Item No. **Report of the Head of Planning, Building Control, Sport & Green Spaces**

Address 734-736 UXBRIDGE ROAD HAYES

Development: Change of use of first and second floors from offices (Use Class B1) to a 9 bedroom House in Multiple Occupancy (Sui Generis), involving installation of roof lanterns to first floor roof and installation of metal gates to side

LBH Ref Nos: **18920/APP/2015/3521**

sd00738/PL10
REV A

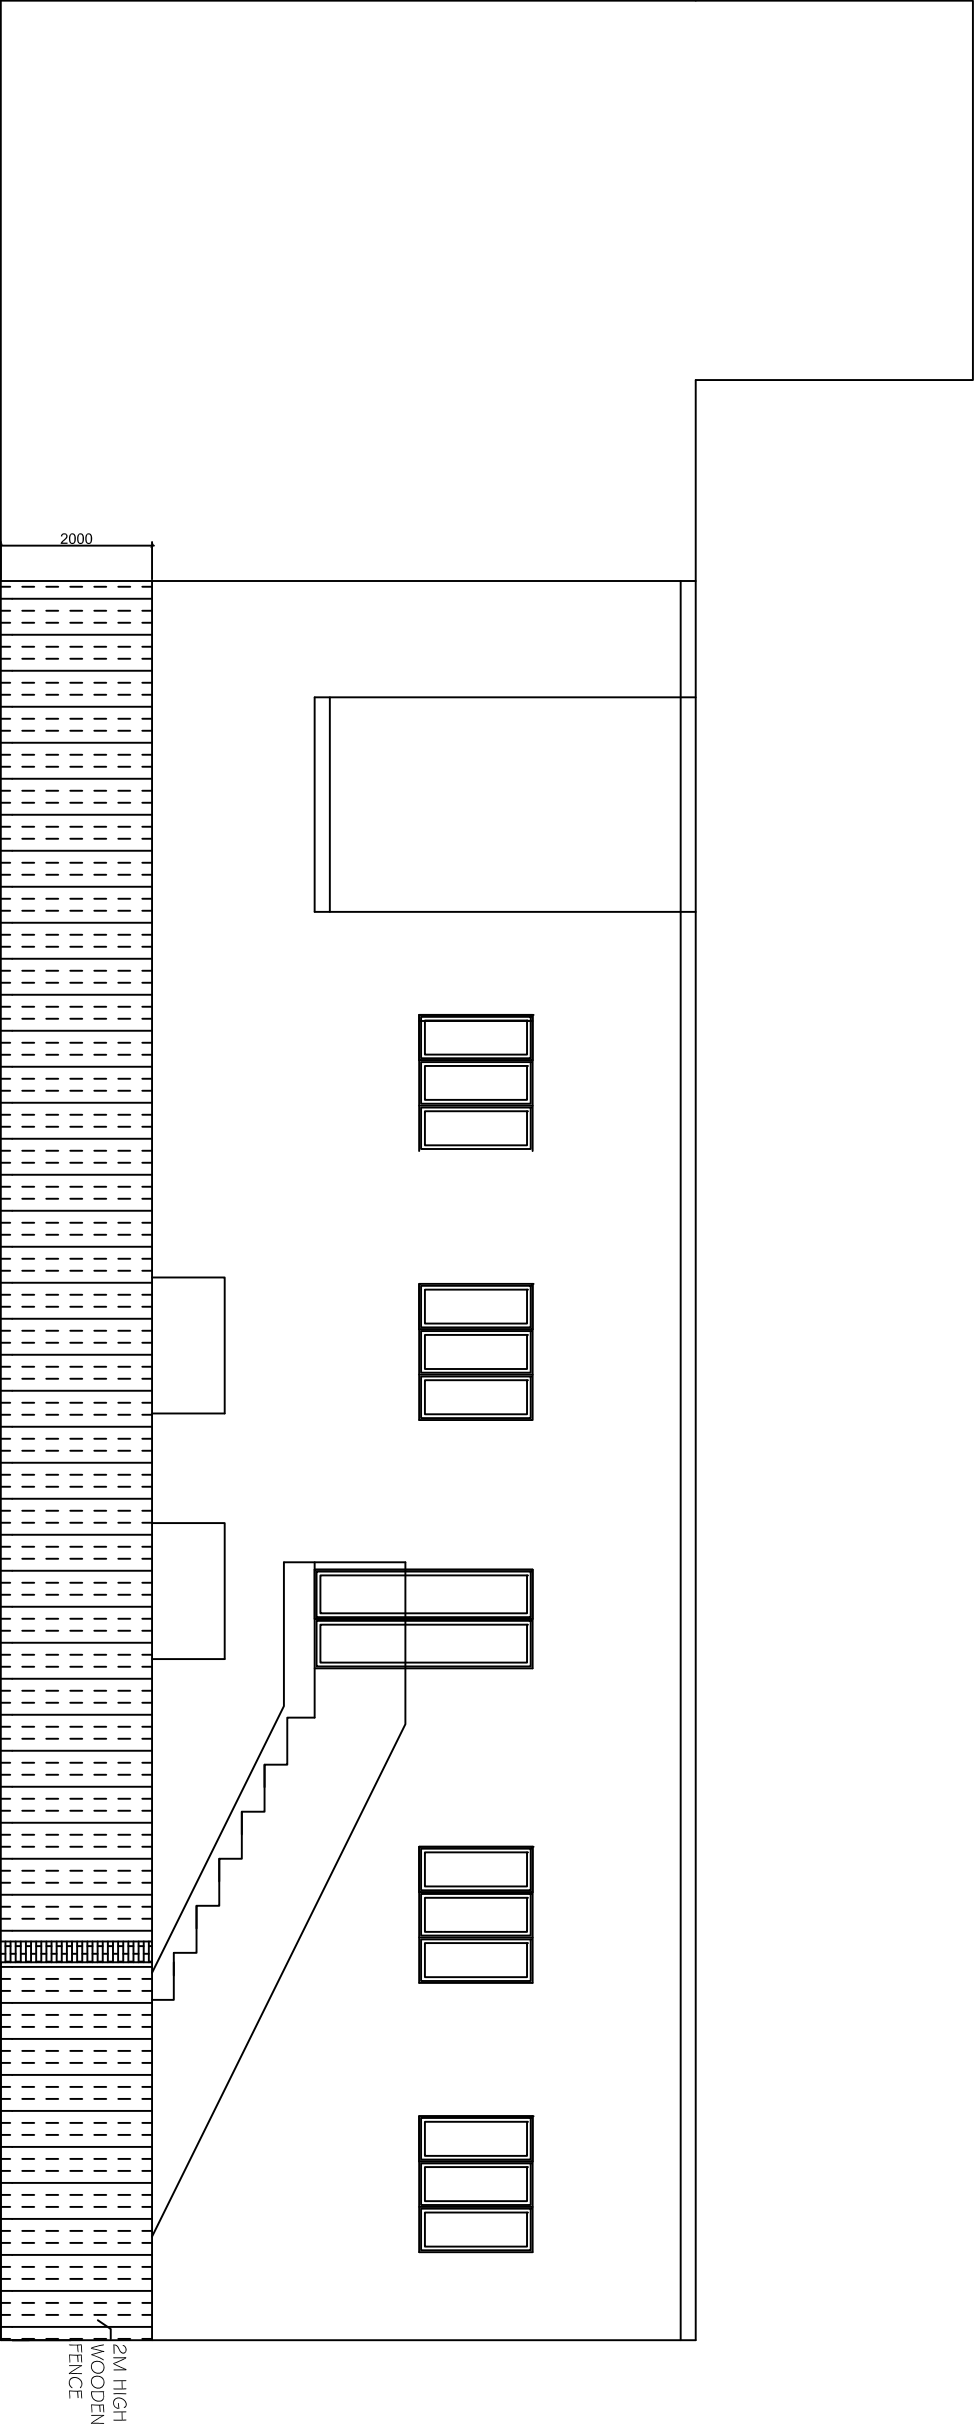
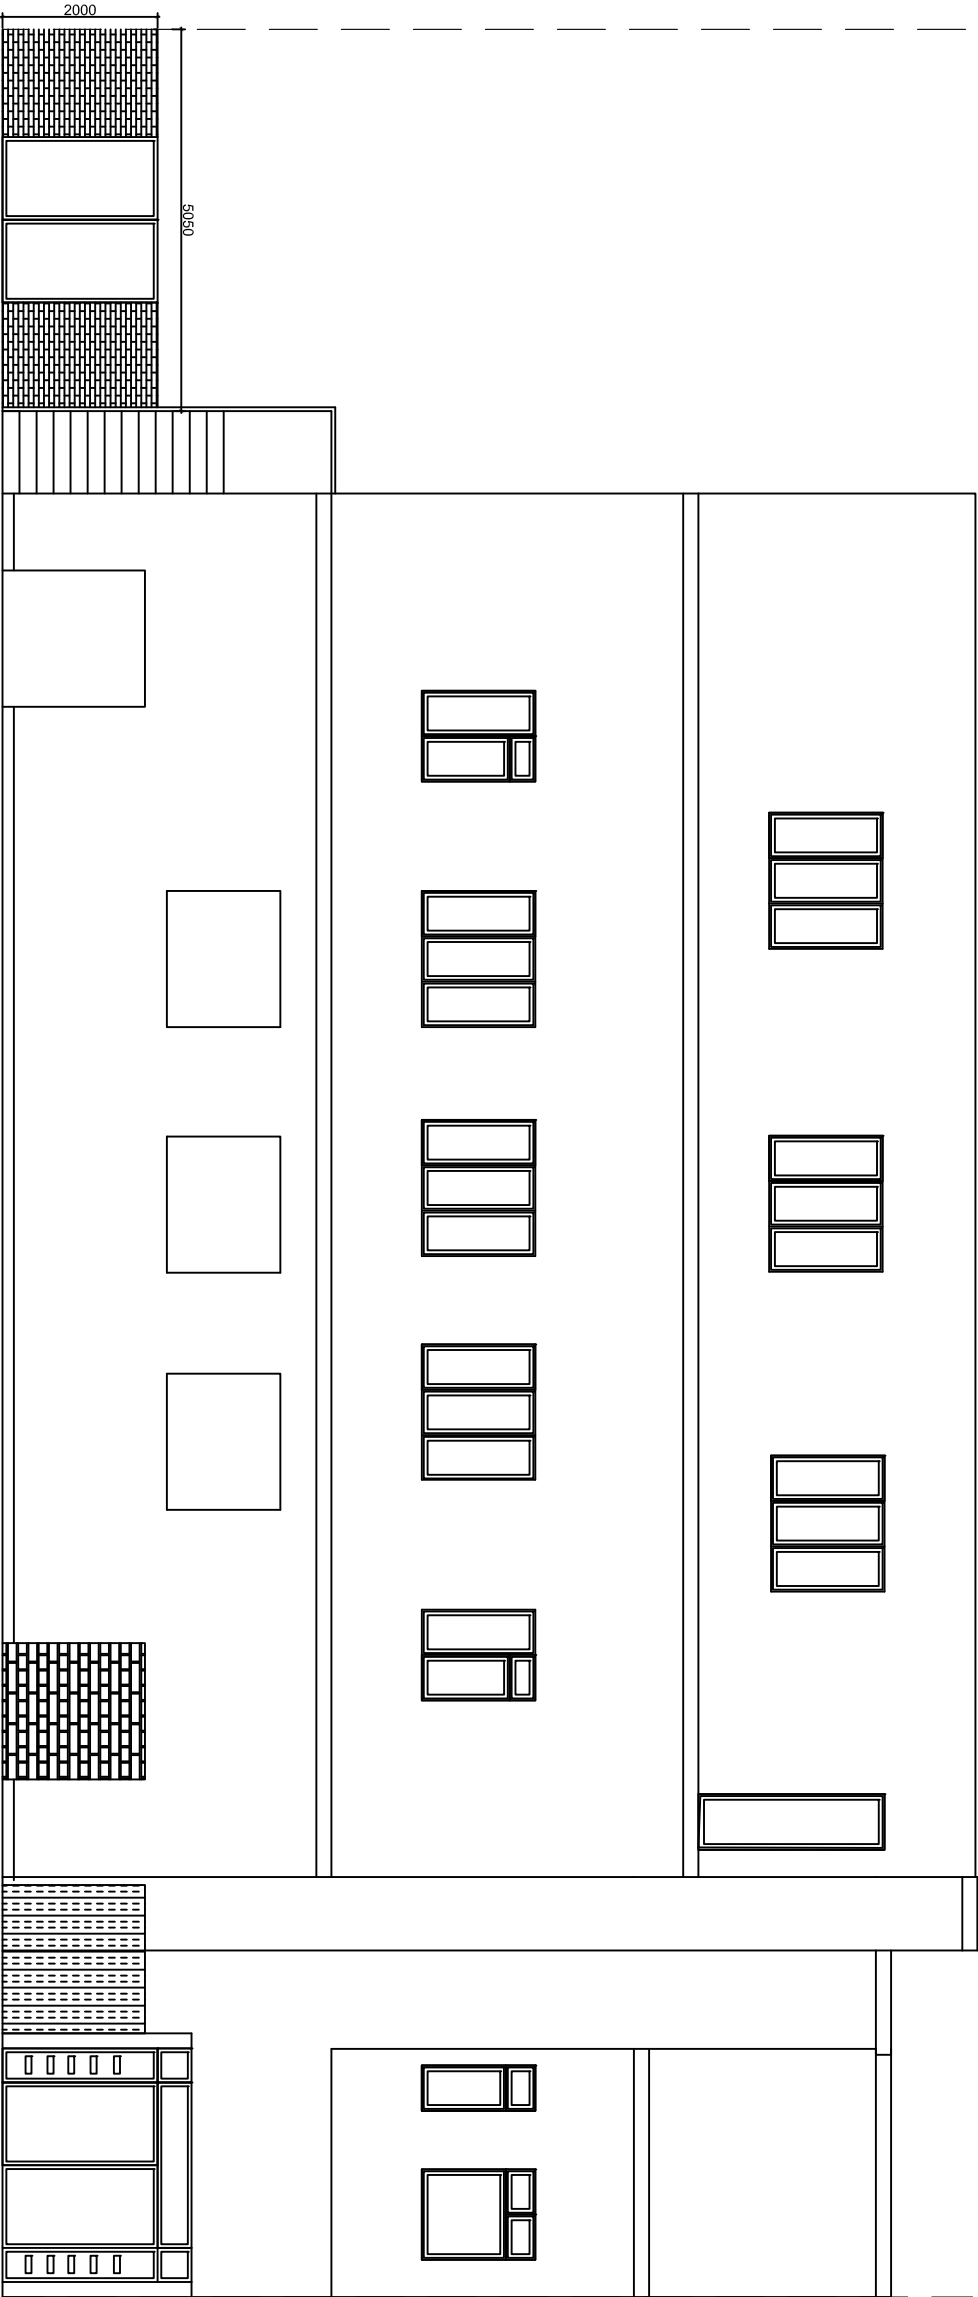
The proposal does not include any external alterations to the main building and the installation of the gates, measuring 2m in height are considered to respect the character and appearance of the rear of the site. As a result it is considered that it would not have a negative impact upon the visual amenity of the site or the surrounding area in compliance with Local Plan policies BE13 and BE15.
